Jean Fraser - Planner
City of Portland
Planning & Urban Development Department
389 Congress Street
Portland, ME 04101

October 16, 2013

Subject: Munjoy Heights
 Preliminary Level III Site Plan Application
 Comment Response Letter

- Woodard & Curran – Peer Review Memo, dated October 9th, 2013.

UNDERDRAINED SUB-SURFACE SAND FILTER
TYPICAL CROSS SECTION
NOT TO SCALE

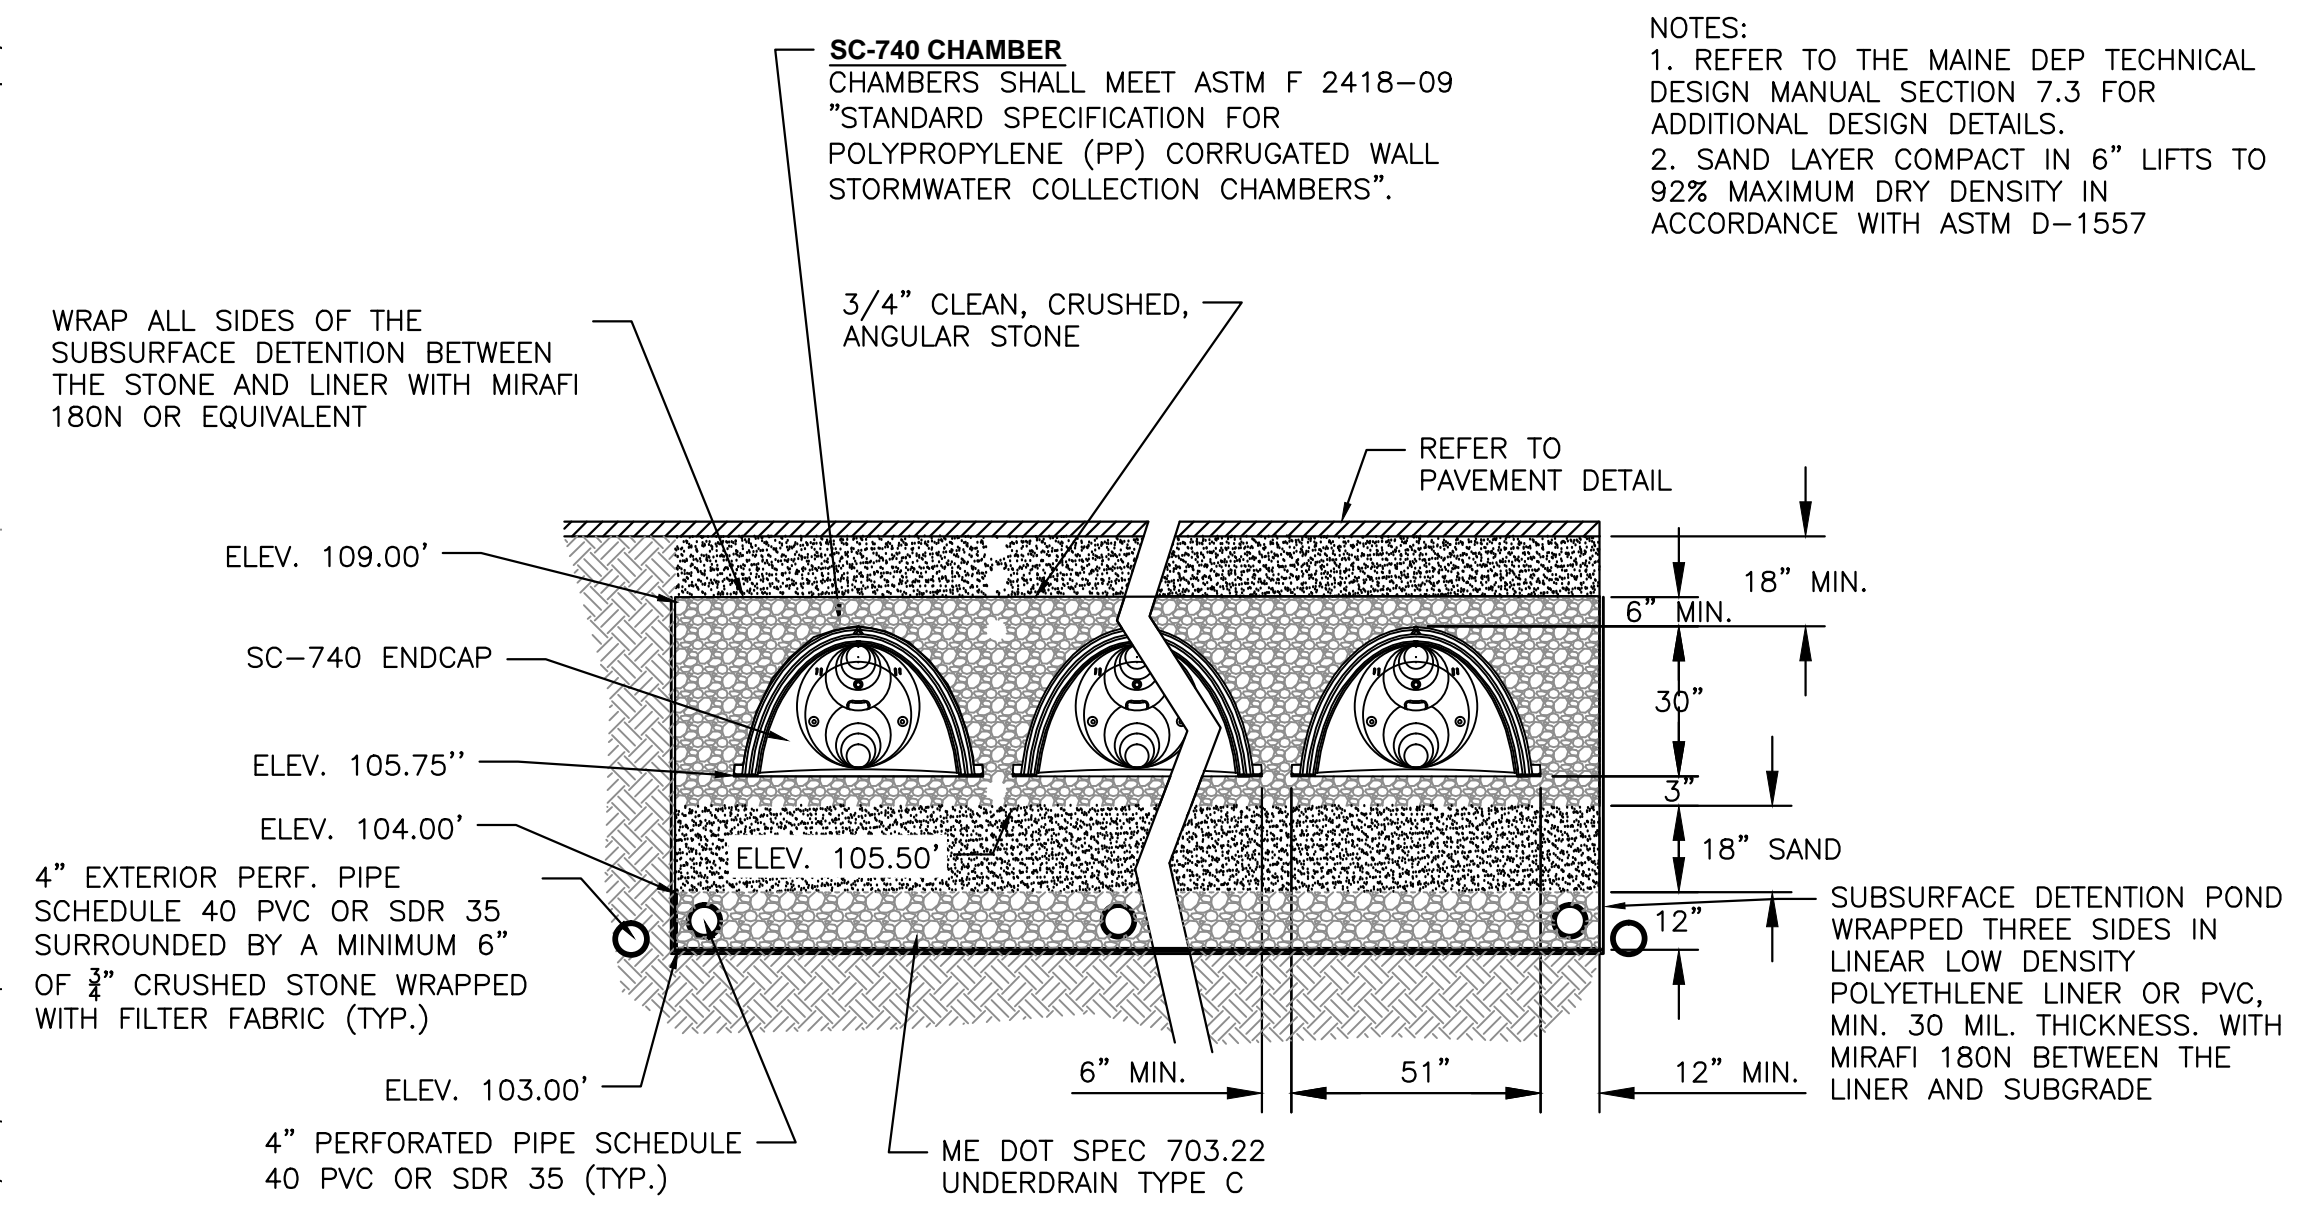
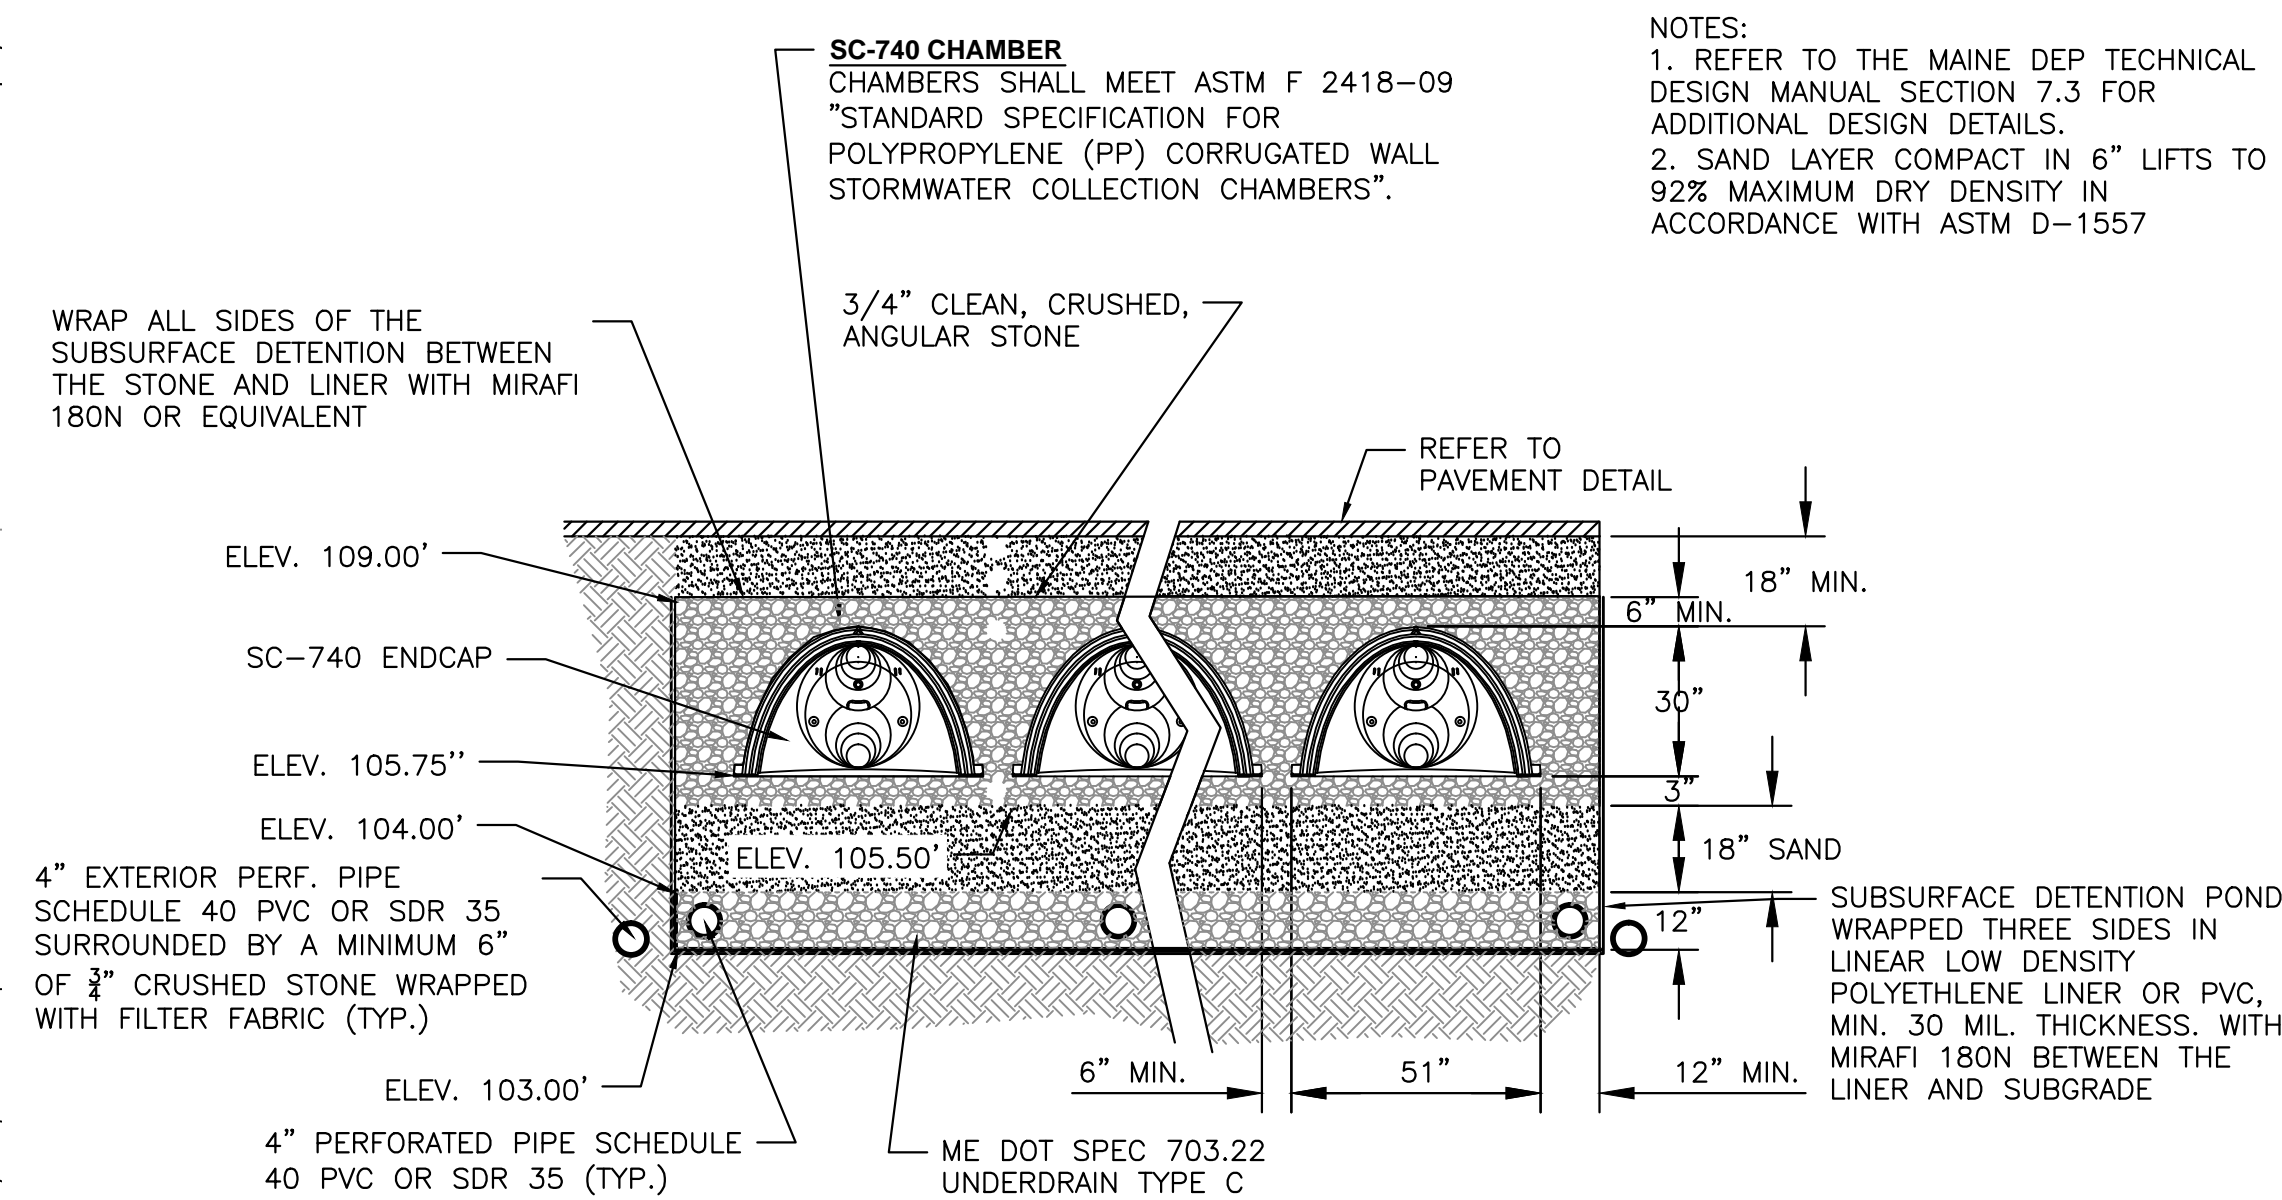
- b. *General Standards: The project will result in a net increase in impervious area of approximately 32,879 square feet. As such, the project is required to provide stormwater management features for stormwater quality treatment. The Applicant has noted that the intent is to provide an Underdrained Subsurface Sand Filter BMP to provide treatment for no less than 95% of the new*

impervious area, and 80% of the developed area. We anticipated that additional notes, details and calculations will be provided to allow us to review the design of this system. In addition, the subsurface stormwater management system is proposed on a steep fill slope; as such, the geotechnical engineer should provide a review of the system design relative to potential impacts on slope stability, foundation drainage, and potential for break-out of infiltrated stormwater on the downhill side of the system.

Response: As part of the Final Application the applicant will document that project meets the Maine DEP Basic, General and Flooding Standard. Furthermore, the geotechnical engineer will review the impacts of the proposed stormwater infrastructure.
